STATE OF NORTH CAROLINA
DEPARTMENT OF TRANSPORTATION

June 15, 2007

Subject: **Revised Nationwide Permit 23 Application** for the proposed replacement of Bridge No. 98 on SR 1246 (Butler Island Road) over Big Swamp, in Sampson County (Division 3). Federal Aid Project No. BRZ-1246(2), State Project No. 8.2281701, TIP No. B-4271, WBS Element 33612.1.1.

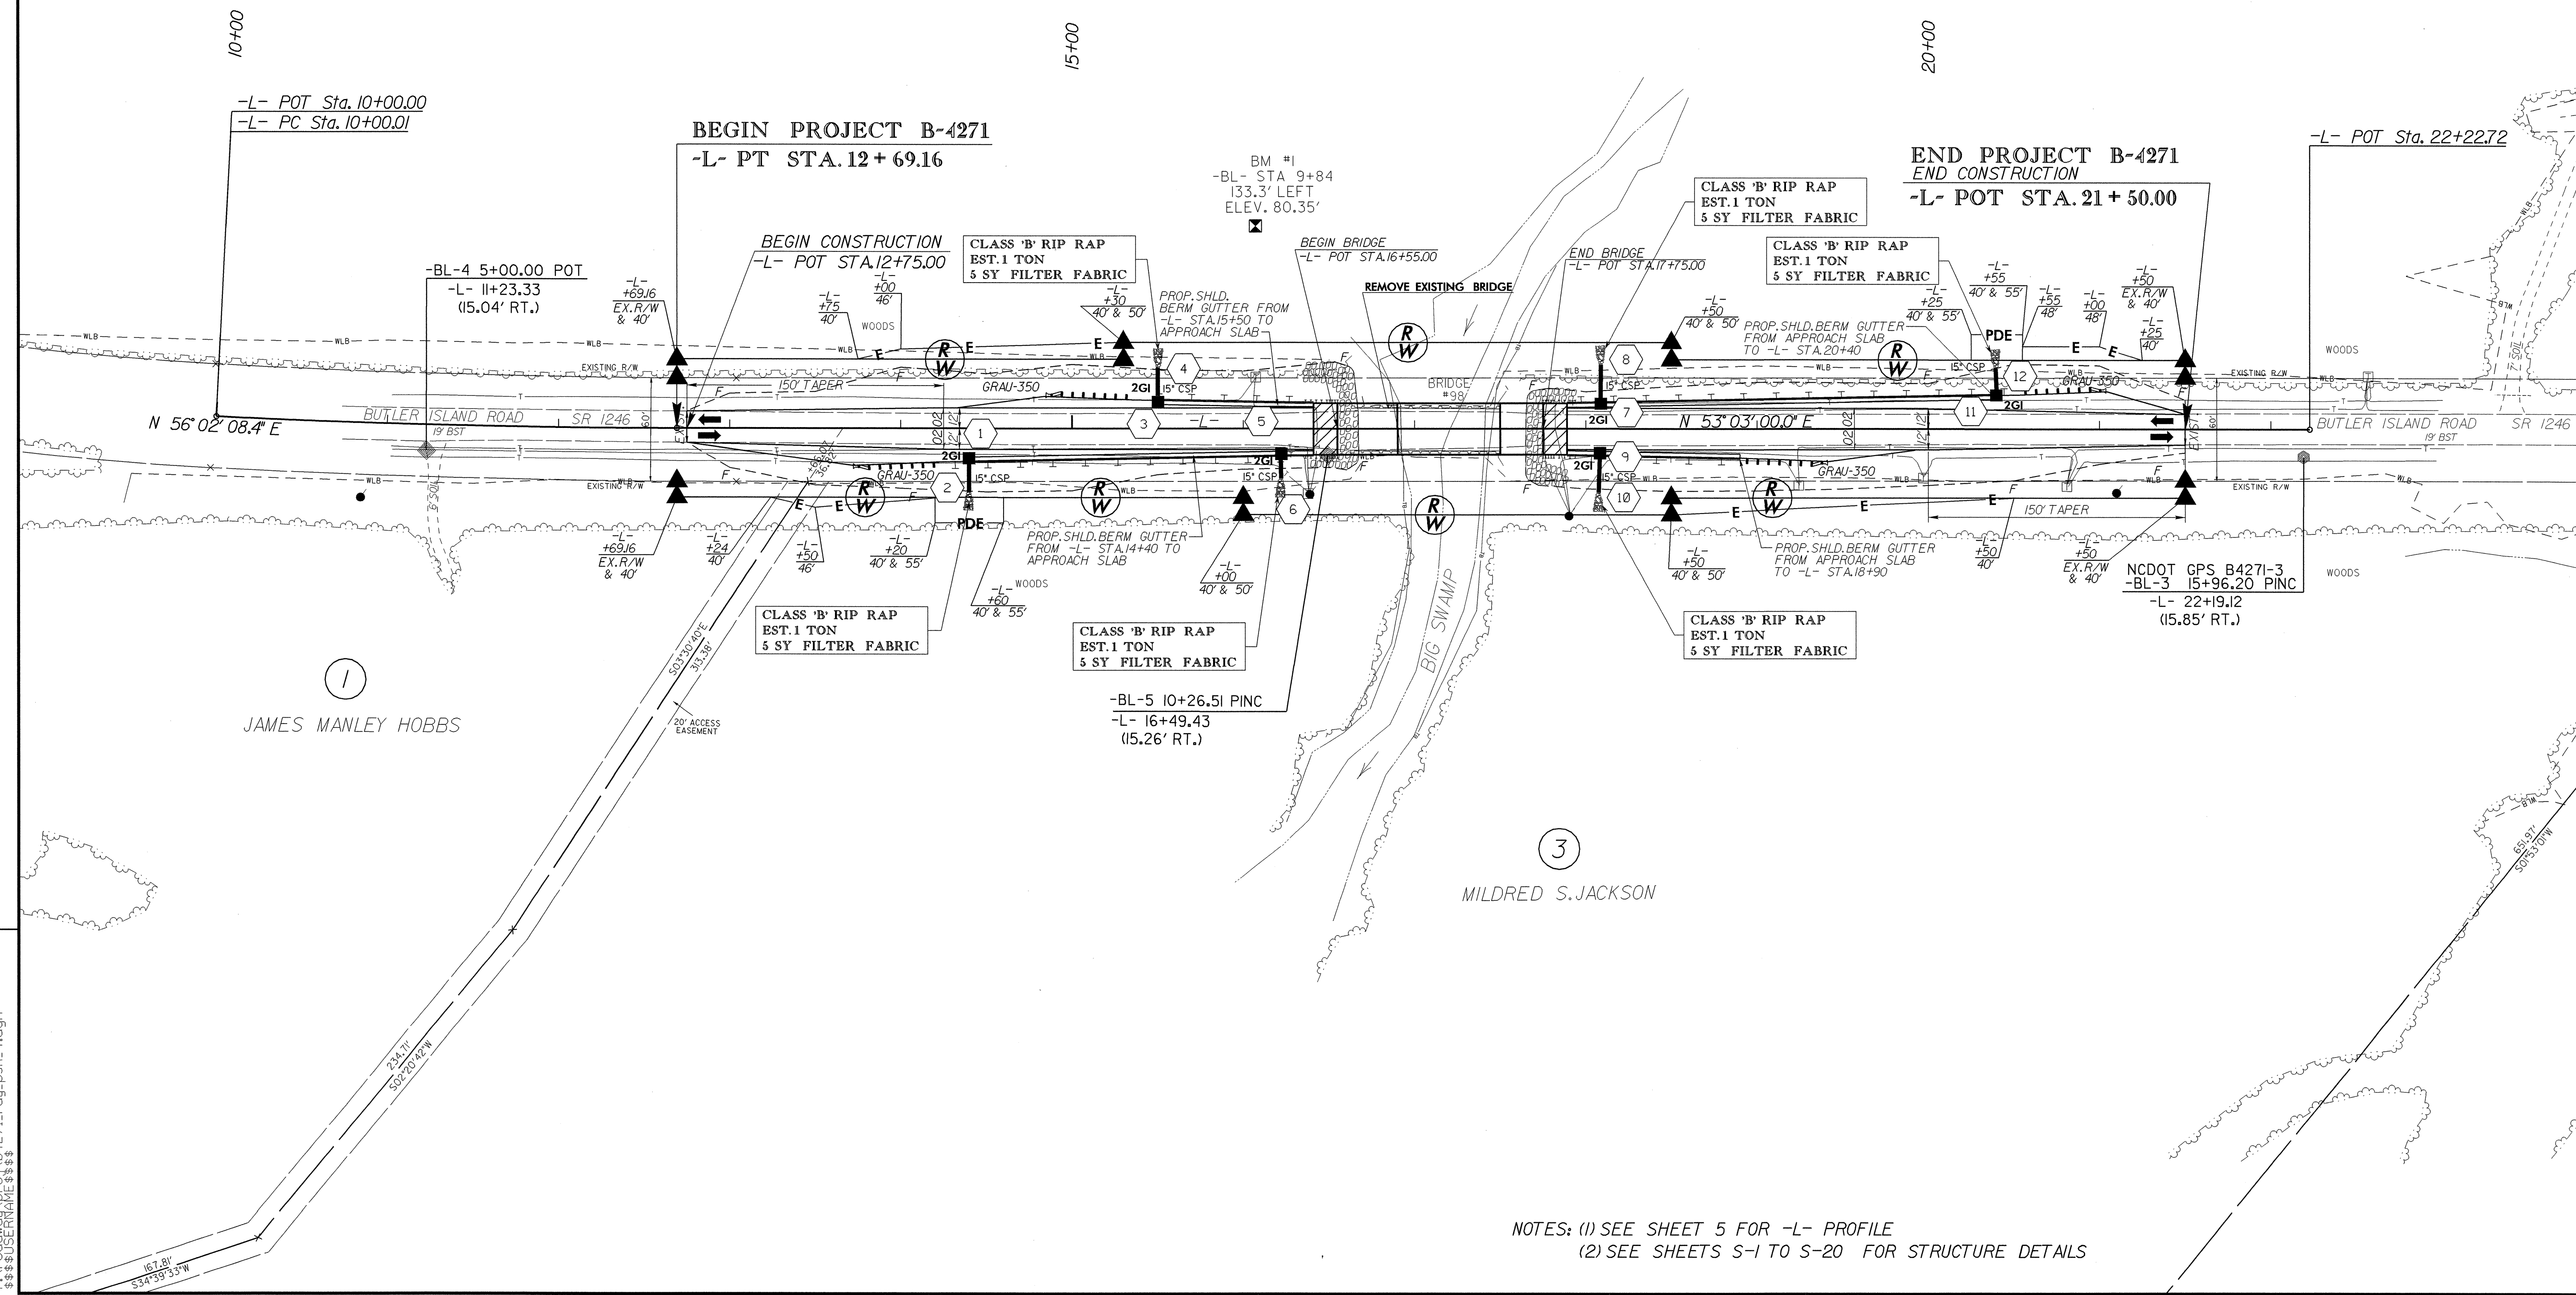
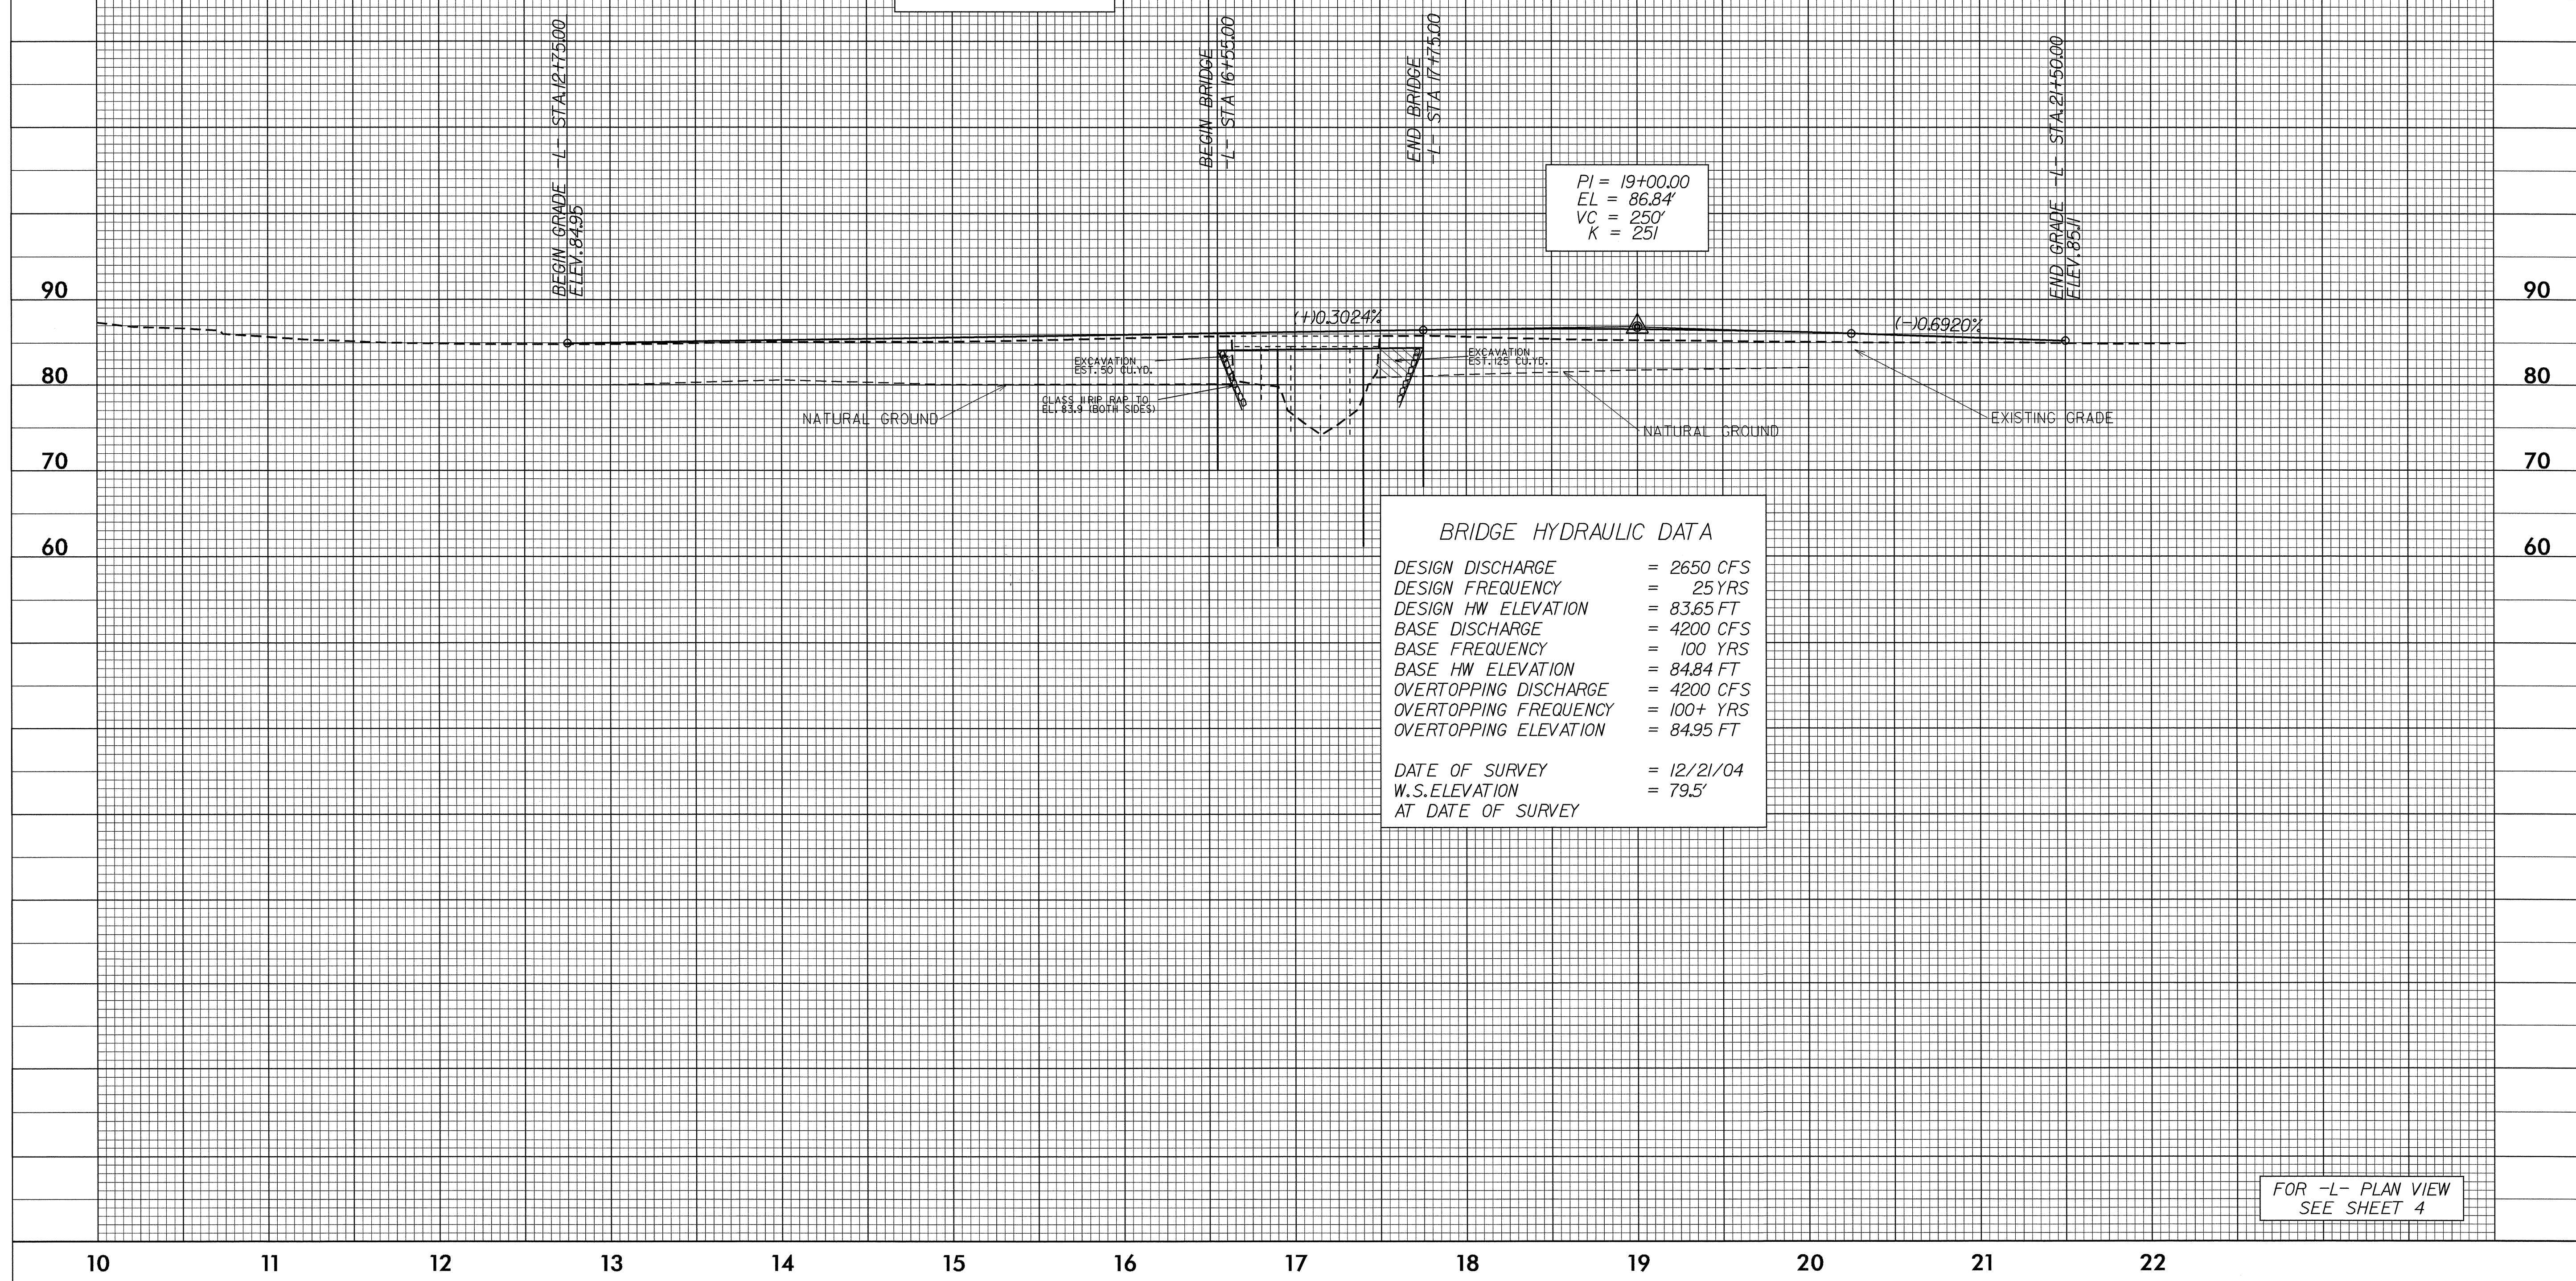
- The new bridge length will be 120 feet long, not 105 feet, with three spans of 35', 50', and 35'.
- The wetland line shown on the permit drawings has been corrected and no longer bisects Big Swamp.
- Impacts originally submitted were not calculated based on 3:1 fill slopes, though the application and cross sections indicated the 3:1 slopes. For this reason, impacts to jurisdictional wetlands have increased from 0.04 ac to 0.05 ac.
- The Wetland Restoration Plan now defines mitigation areas more clearly.
